Application by Ecotricity (Heck Fen Solar) Limited  
Heckington Fen Solar Park

## **The Examining Authority's written questions and requests for information (ExQ1) Issued on 17 October 2023**

- KEY**
- Order Limits
  - Work No. 6A, 6B and 6C
  - Work No. 6C

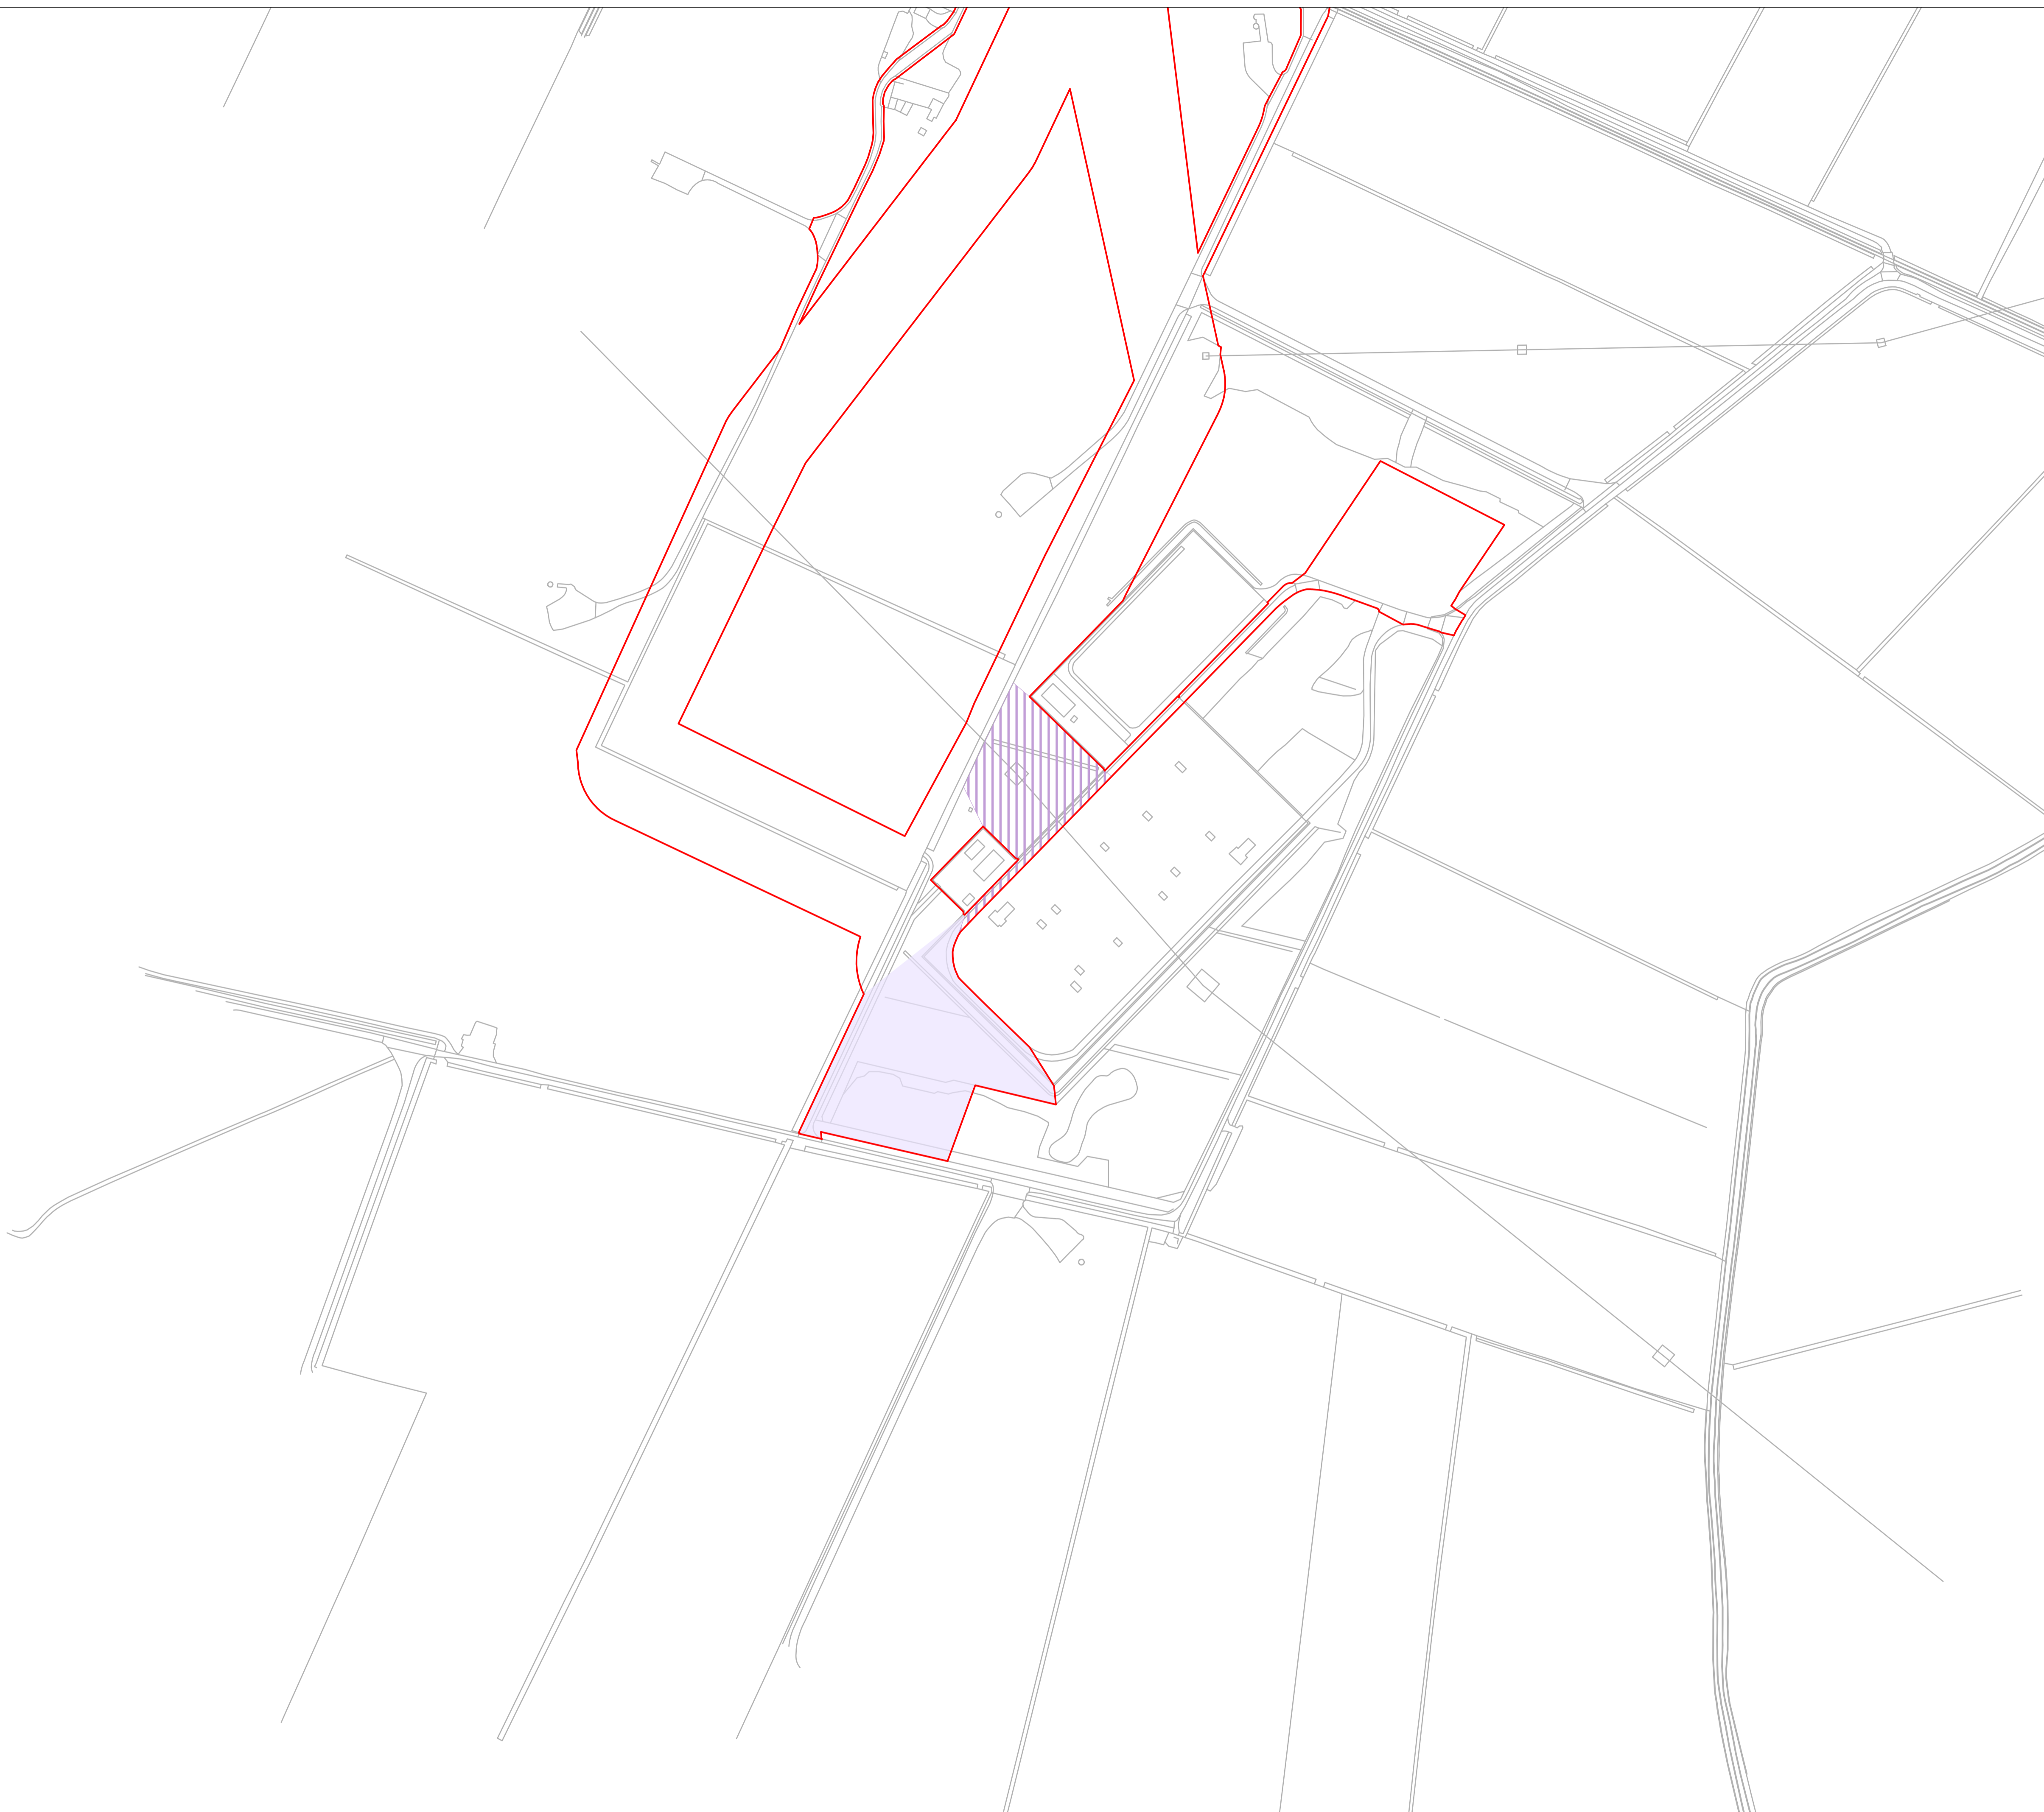
<b>ExQ1</b>	<b>Question to:</b>	<b>Question:</b>
<b>1. GENERAL, MISCELLANEOUS AND CROSS-TOPIC QUESTIONS</b>		
GEN.1.1	Applicant	<p>Sheets 5, 6, 12 and 13 of the Works Plans [PS-014] show numerous overlapping Works No's around the on-site substation and the Bicker Fen substation. Due to the scale of the plans and the overlapping colours/patterns the exact boundaries of many of the Work No's in these areas of the Proposed Development are ambiguous.</p> <p>Provide individual plans to clearly show the extent of each of the Work No's in these areas. These should not supersede the Works Plans but would be supplementary to them.</p>
GEN.1.2	Applicant	<p>Paragraph 3.4.1 of Environmental Statement (ES) Chapter 3 [PS-053] states that the layout of the Proposed Development has evolved taking into account "<i>planning and environmental policy objectives</i>".</p> <p>Could the Applicant provide further detail for each of the relevant "<i>environmental policy objectives</i>" and design objectives set out within the Statement of Need and Planning Statement [PS-142], and how these have been taken into account within the iterative design process described within the ES.</p>
